**From:** Bob Neville  
**Sent:** 04 January 2021 09:07  
**To:** DC Support  
**Subject:** FW: Planning notification for application reference: 20/03353/OUT  
**Attachments:** eCon\_(4).pdf

**From:** patrickprendergast@bucksplantcare.co.uk <patrickprendergast@bucksplantcare.co.uk>  
**Sent:** 03 January 2021 17:42  
**To:** Bob Neville <Bob.Neville@cherwell-dc.gov.uk>  
**Cc:** Paul Almond <Paul.Almond@Cherwell-DC.gov.uk>  
**Subject:** FW: Planning notification for application reference: 20/03353/OUT

I am commenting on the above application from an arboricultural aspect.

Title **TREE CONSTRAINTS PLAN**

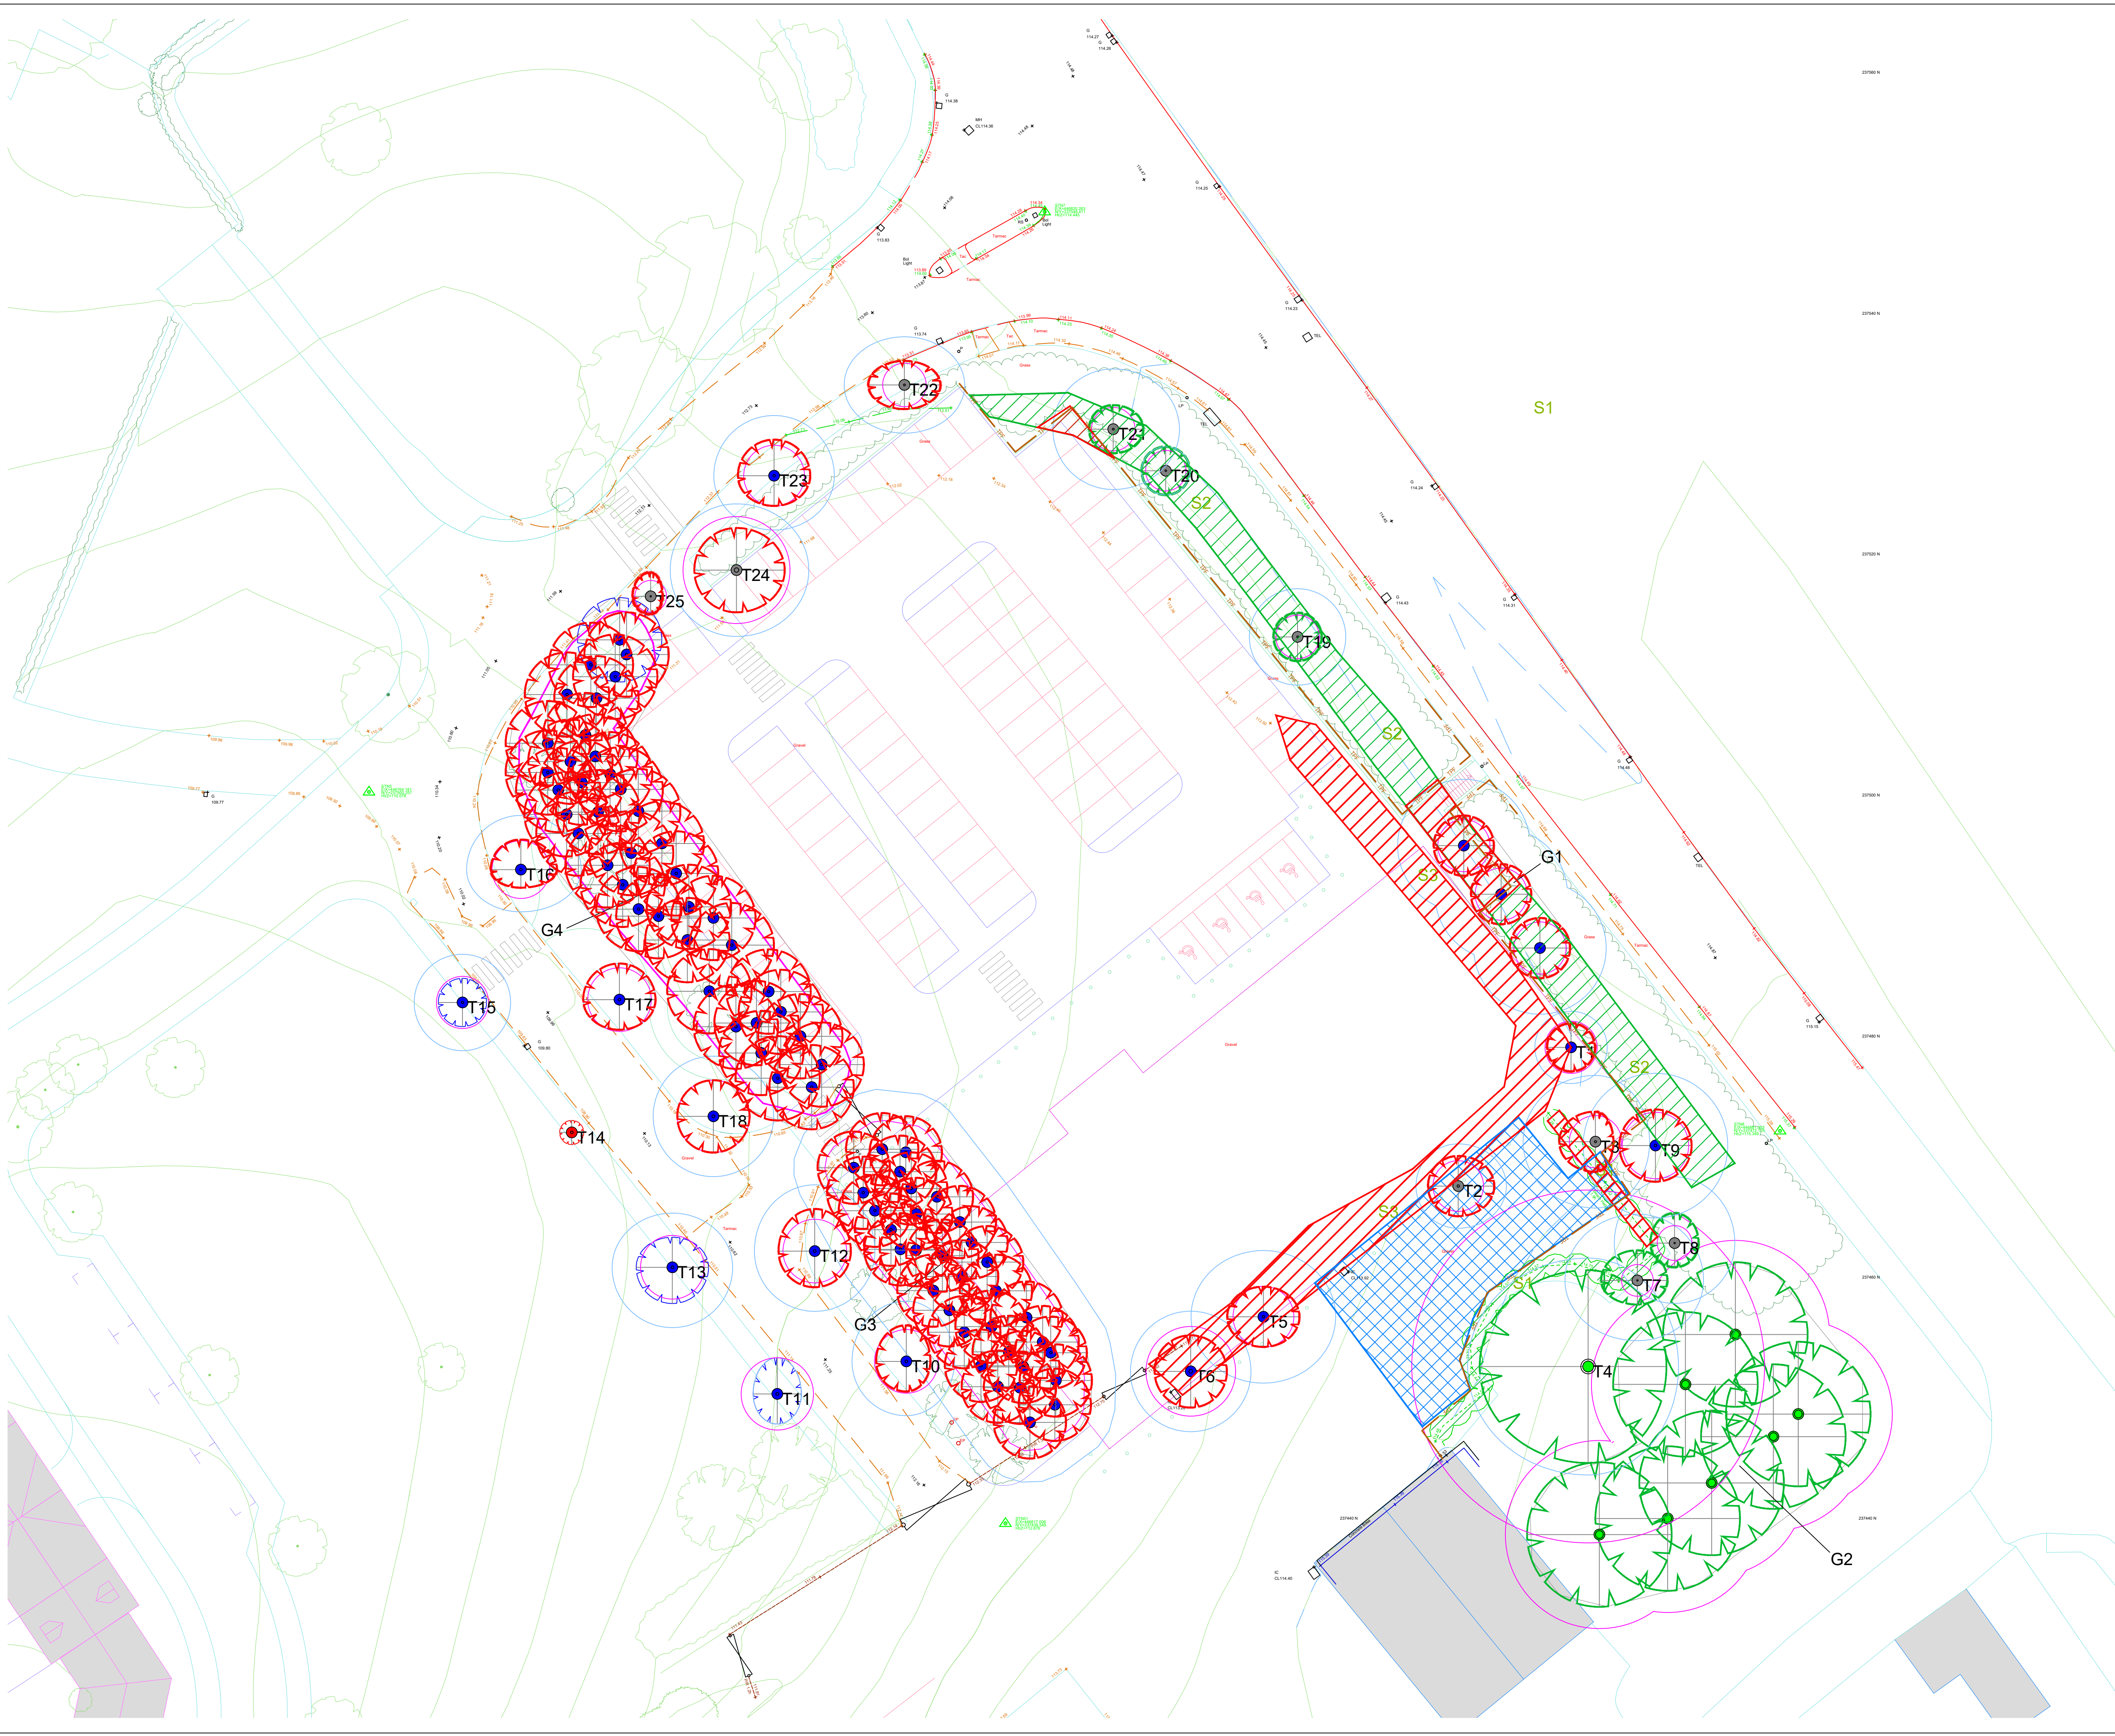
I have studied the plans and the Arboricultural information, which is limited to the survey and constraints plan. A full tree report is required in line with BS5837 to include an impact assessment and tree protection plan.
